EL PASO COUNTY GRADING AND EROSION CONTROL PLAN CHECKLIST

EPC Project Number: PPR2415

GRADING & EROSION CONTROL PLAN
EROSION CONTROL
C1.6 MVE PROJECT 61203
MVE DRAWING GEC-EC
MARCH 21, 2024
SHEET 6 OF 8

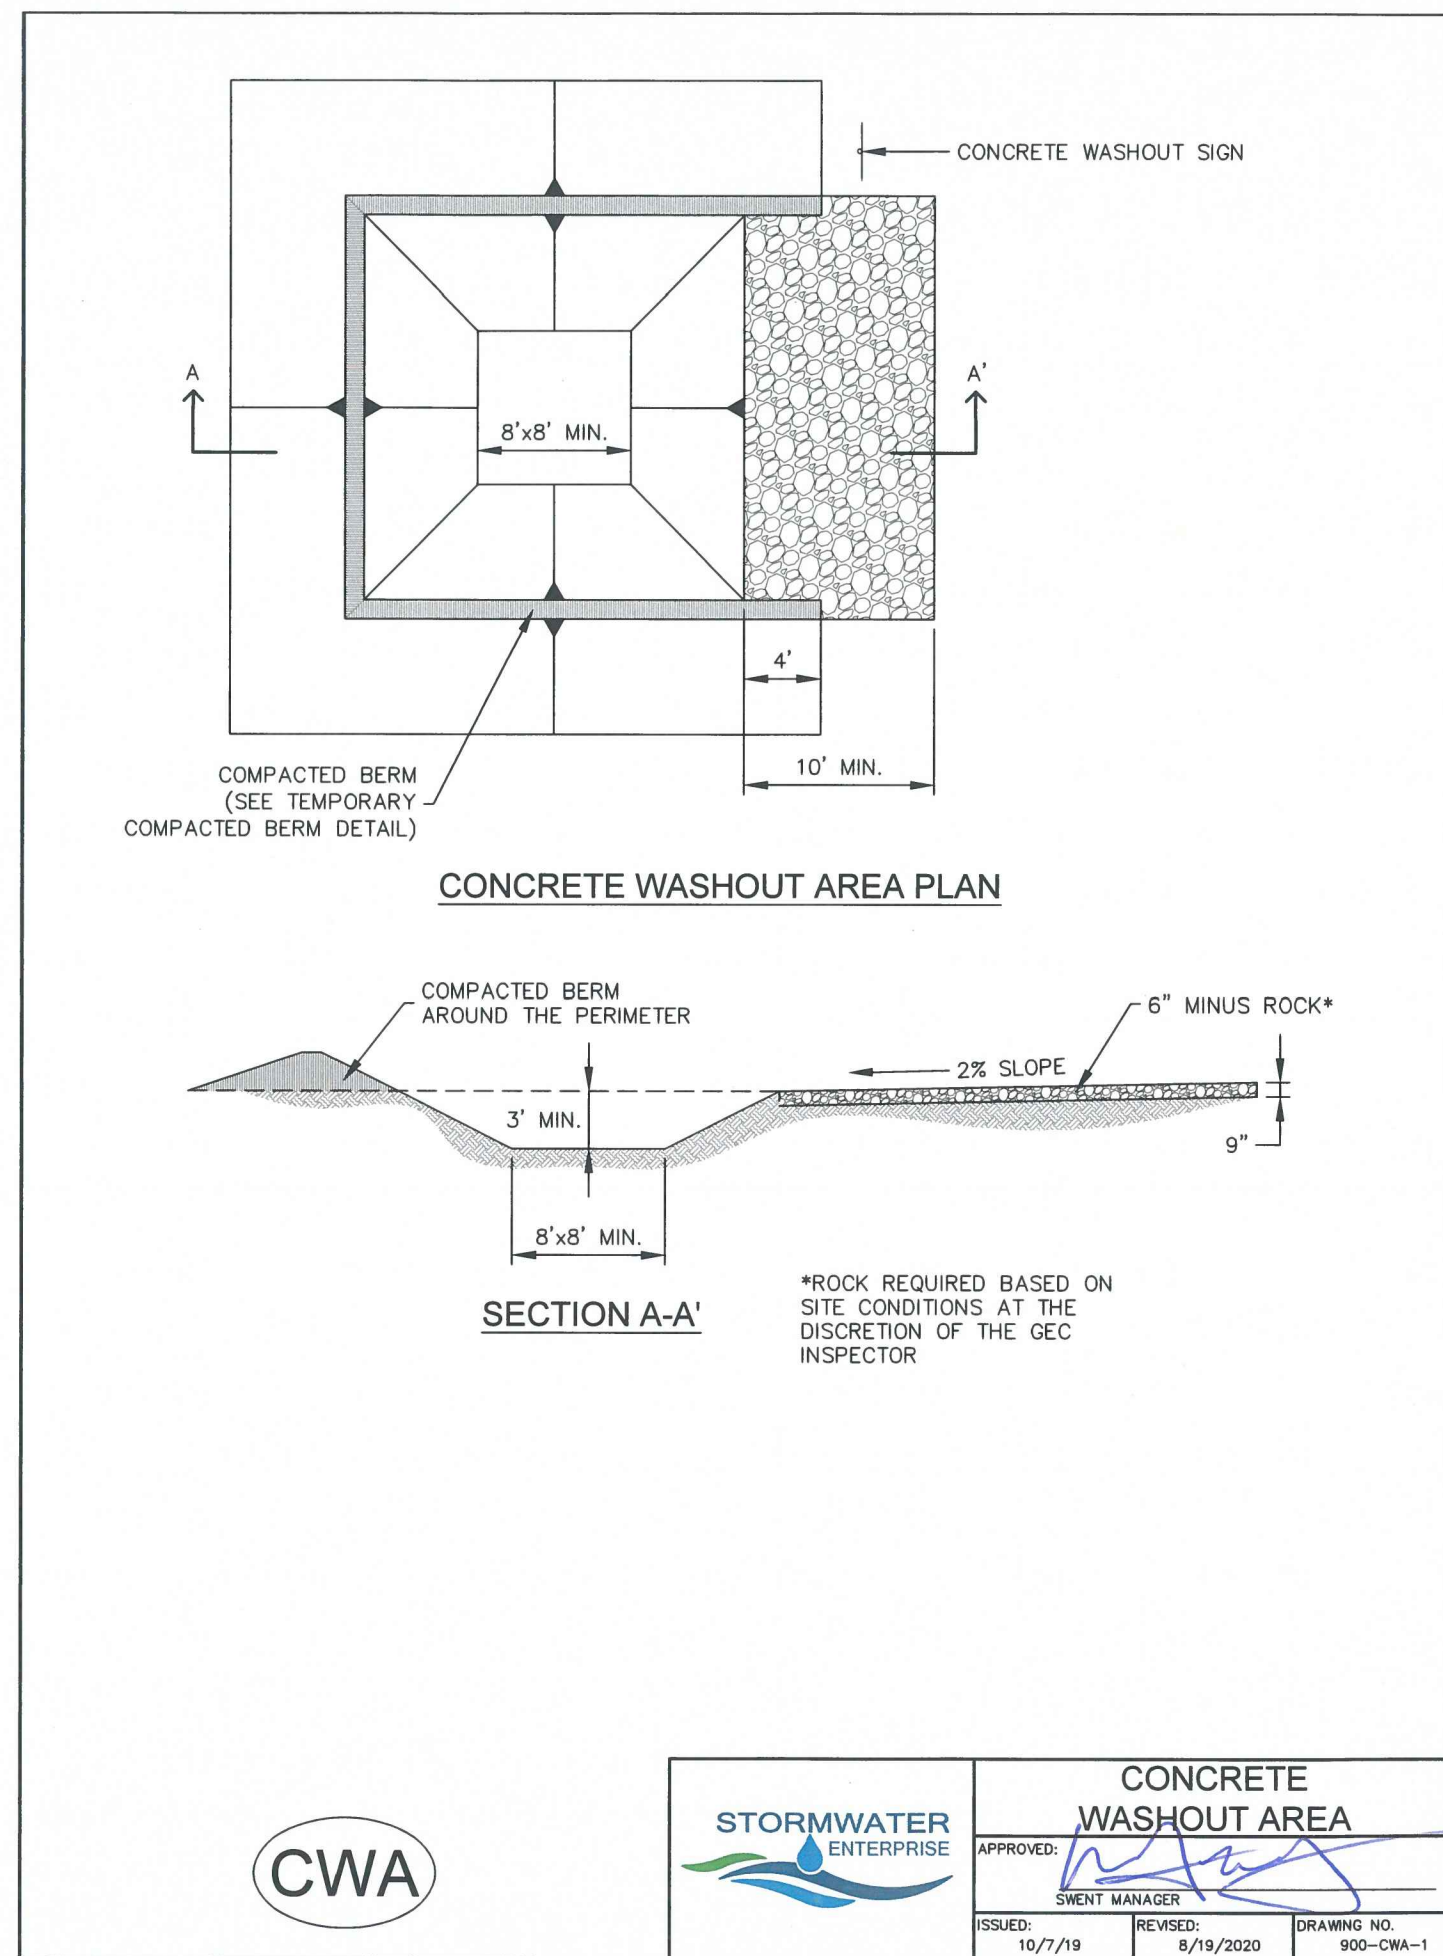
v	All proposed temporary construction control measures, structural and non-structural. Temporary construction control measures shall be identified by phase of implementation to include "initial," "interim," and "final" or shown on separate phased maps identifying each phase		Y
w	Vehicle tracking provided at all construction entrances/exits. Construction fencing, barricades, and/or signage provided at access points not to be used for construction		Y
x	Temporary sediment ponds provided for disturbed drainage areas greater than 1 acre

See my comment on Sht 6 of GEC Plans
